Reference: NZ Uptown Office Building
6100 Indian School Road, NE
Drainage Inspection (J18-D7)

Re: 6100 Indian School Road NE - Drainage Inspection (J18-D7)

With respect to our discussion on 11/16/82, the referenced site was surveyed and the following is a list of items at variance with the approved plan dated 7/15/81.

UTILITIES SITE PLAN

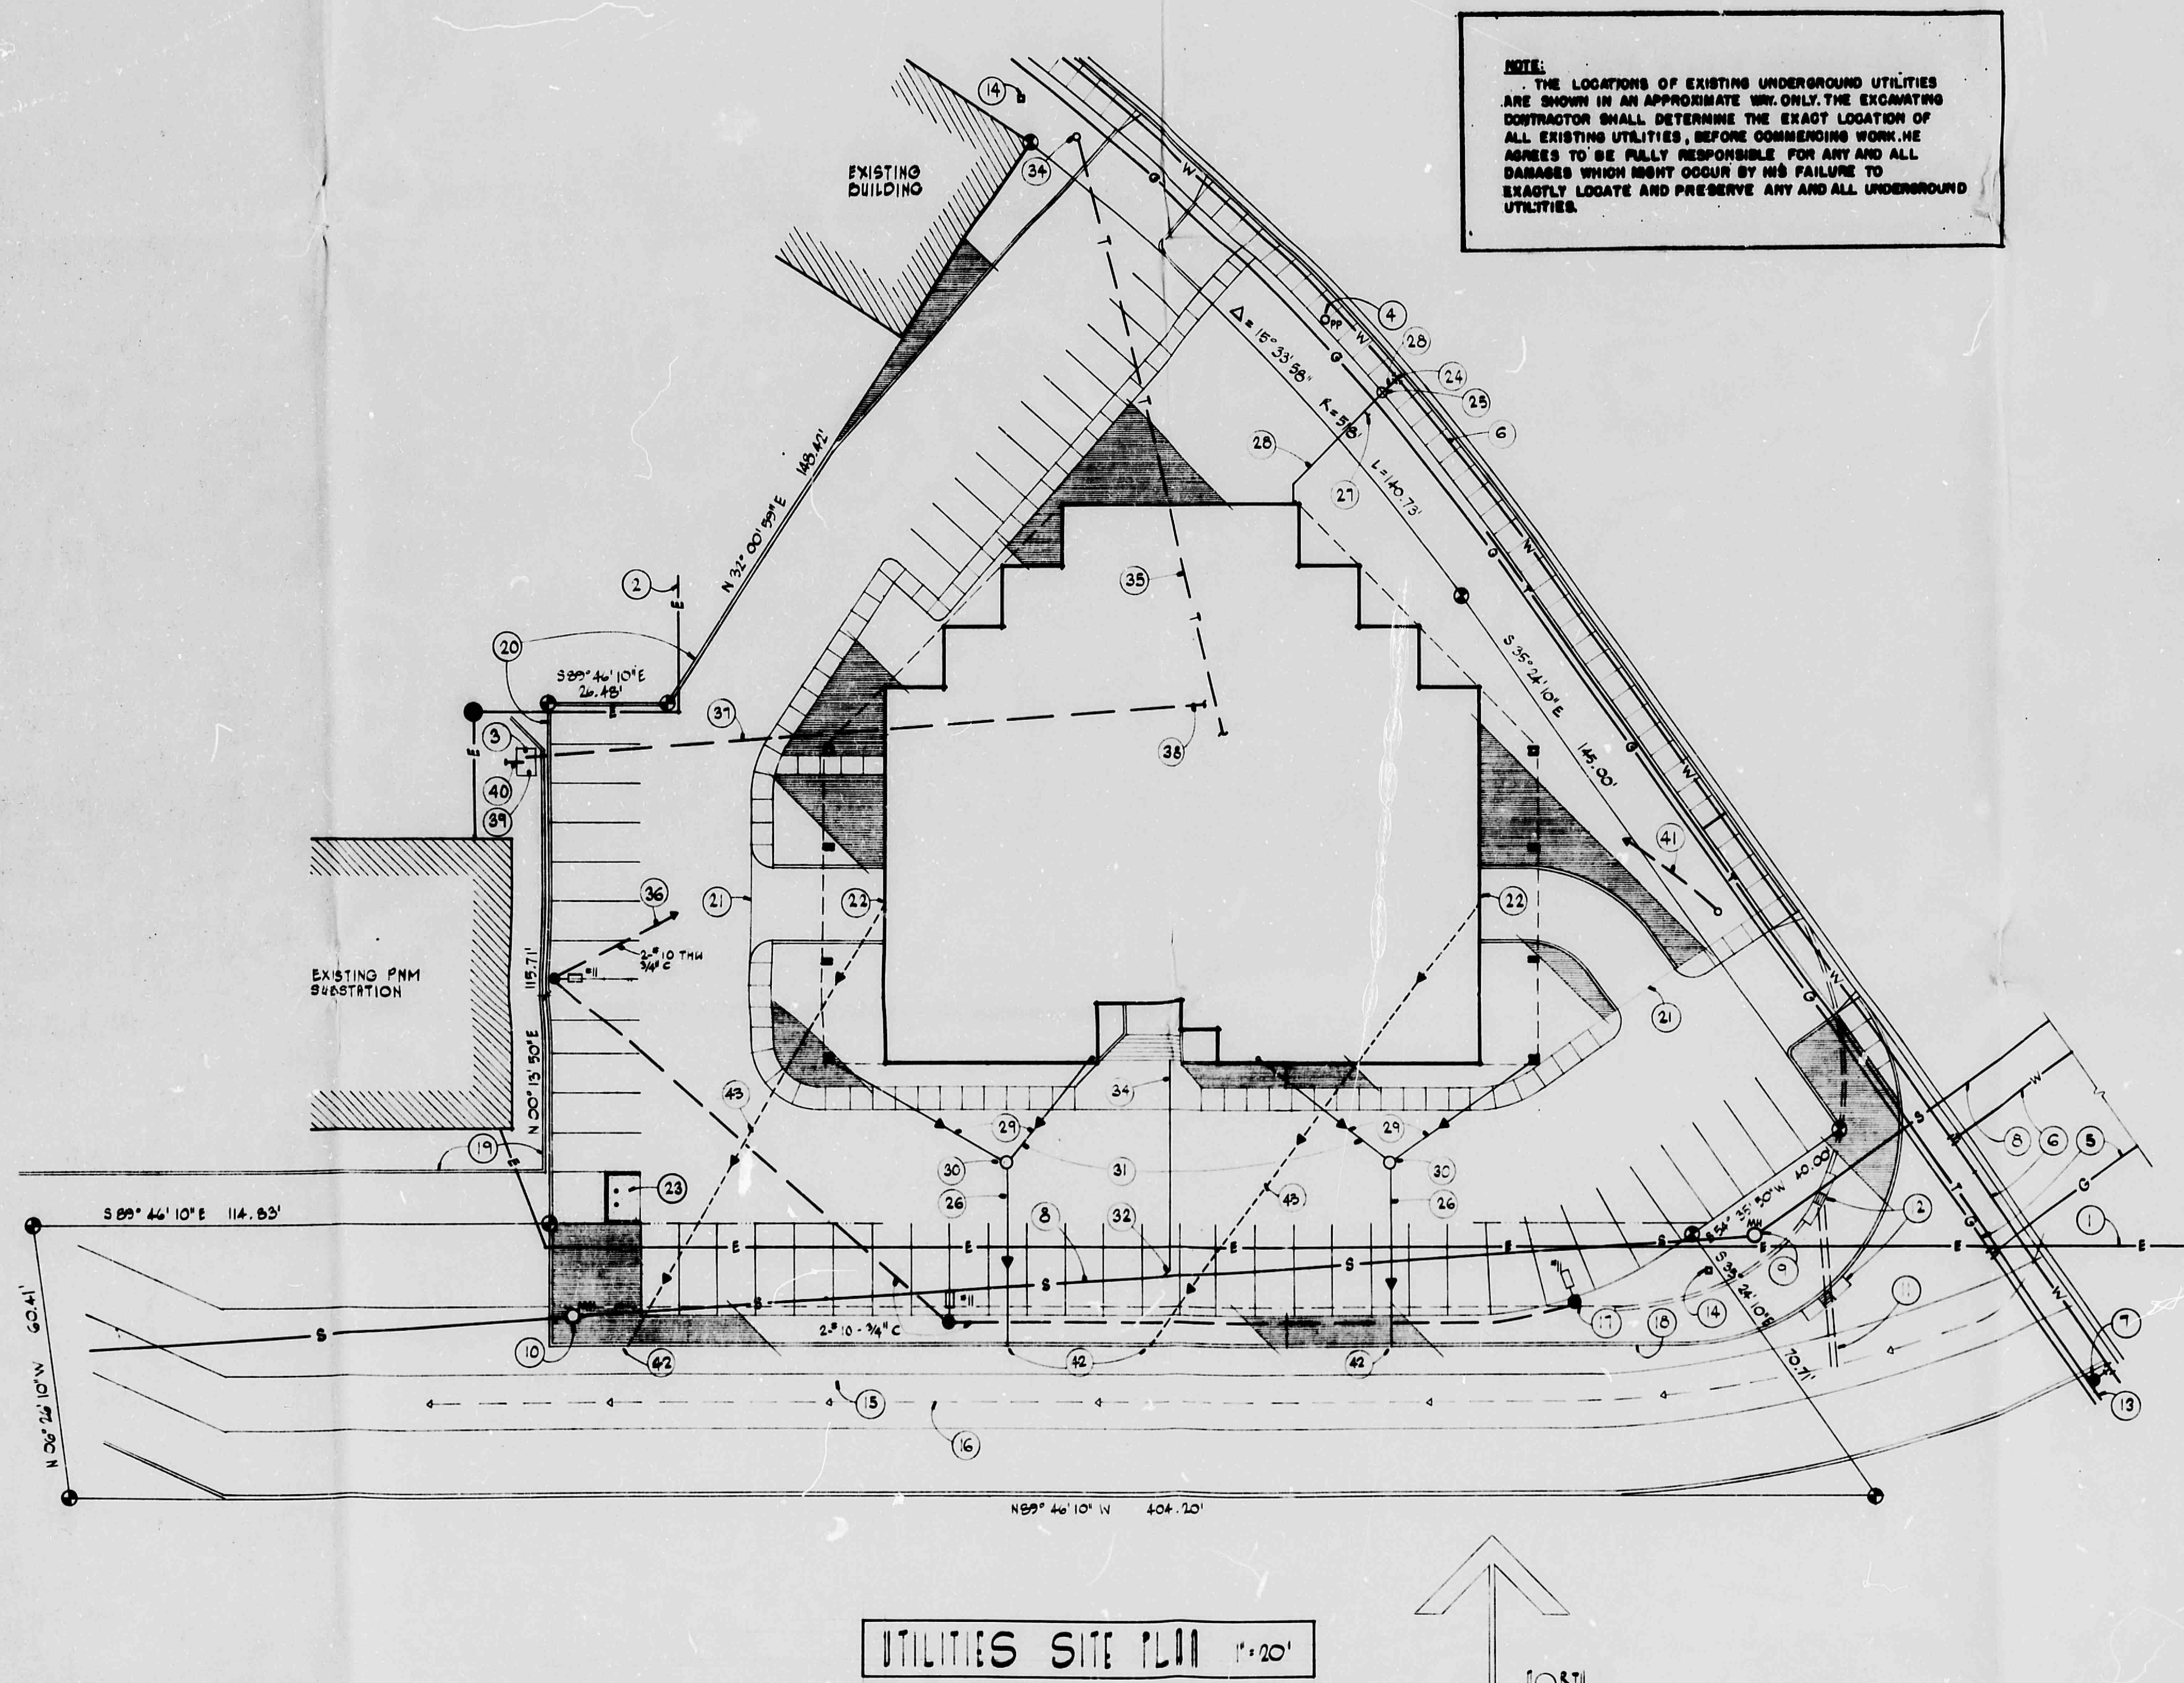
4. Roof and basement drains were not constructed per plan.

Note: Submit a revised C-2 sheet reflecting these changes.

TITLE:	TRACT D-6 GRADING & DRAINAGE PLAN
--------	--------------------------------------

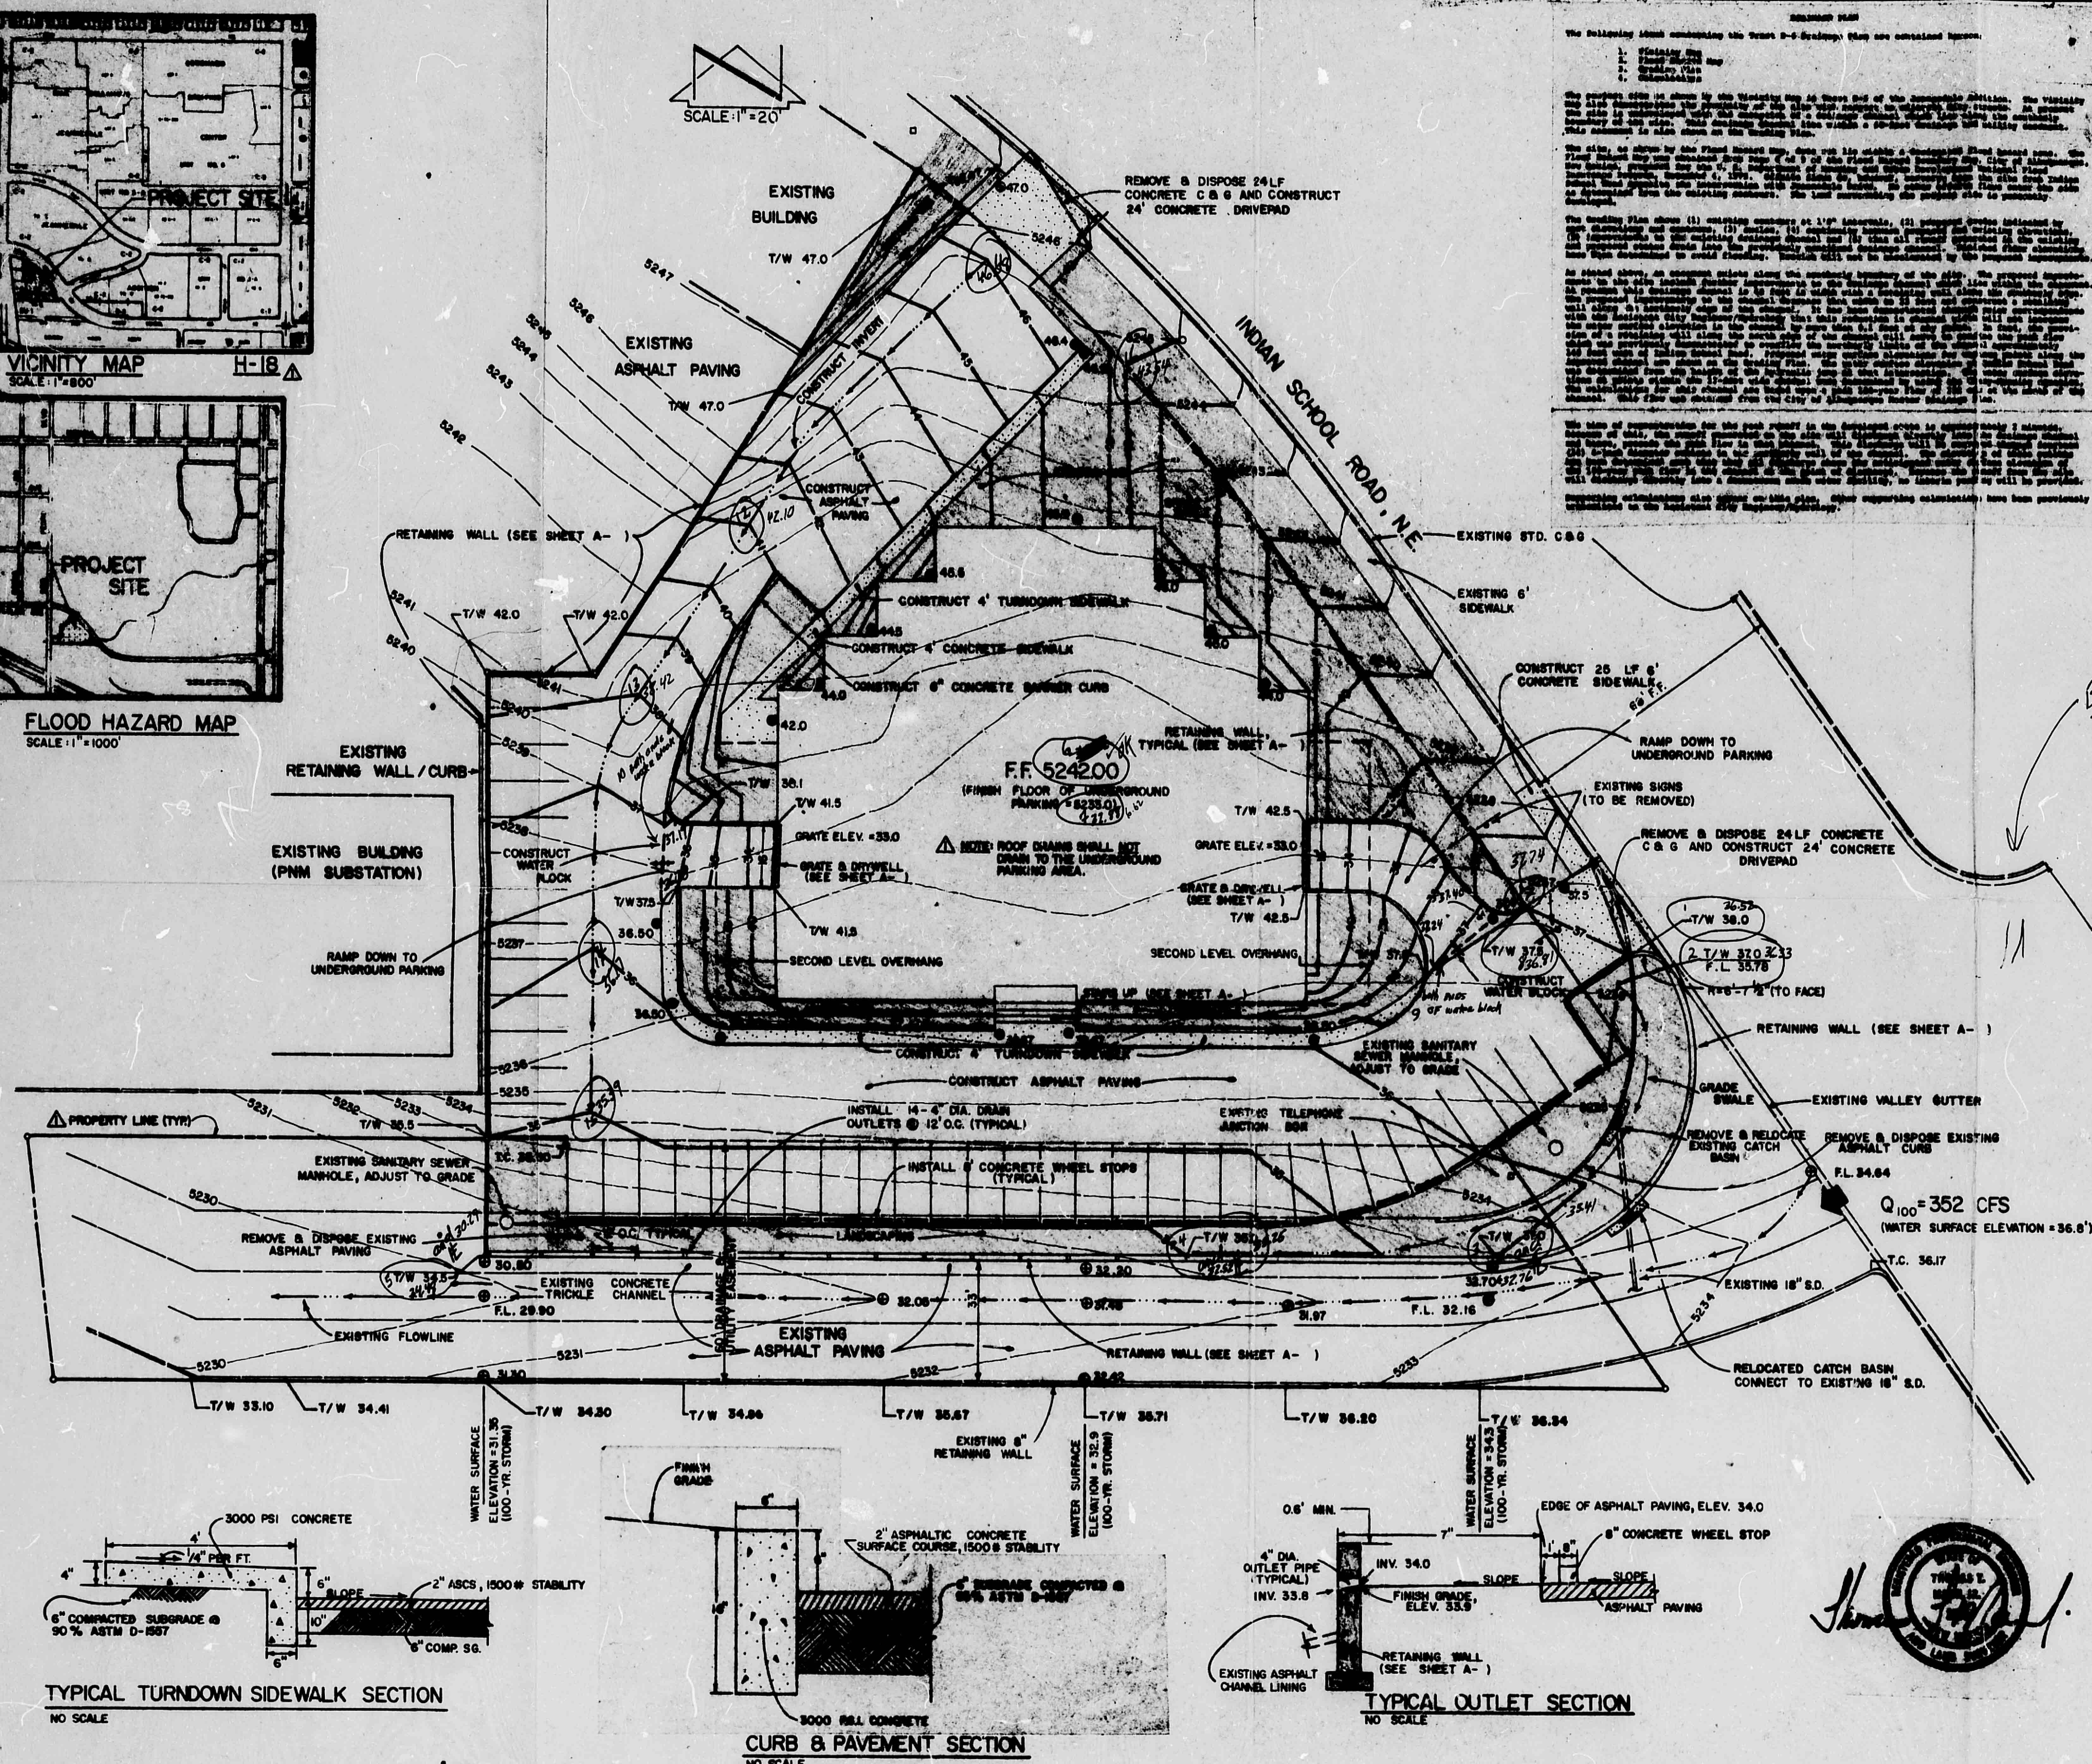
1. The required retaining wall elevations at the channel entrance from Indian School Road was not constructed per plan. (survey available at our office).
2. The required grading for the landscaping around the building was not graded per plan. The landscaping slopes towards the structure thus allowing runoff (landscaping or storm water) to enter the basement.

3. Ten-2" diameter drain pipes were constructed as opposed to the Fourteen-4" diameter drain pipes required by plan.

Note: This grade change is acceptable to this office, since it does not affect the drainage concept, if the owner concurs with the change.

Note: Again, this office has no objections as long as the owner agrees with this change.

In view of the changes outlined above, this office must require a revised plan prepared by your engineer incorporating the changes discussed above. Included with this plan must be recommendations on how to bring the site into compliance with the approved drainage concept.
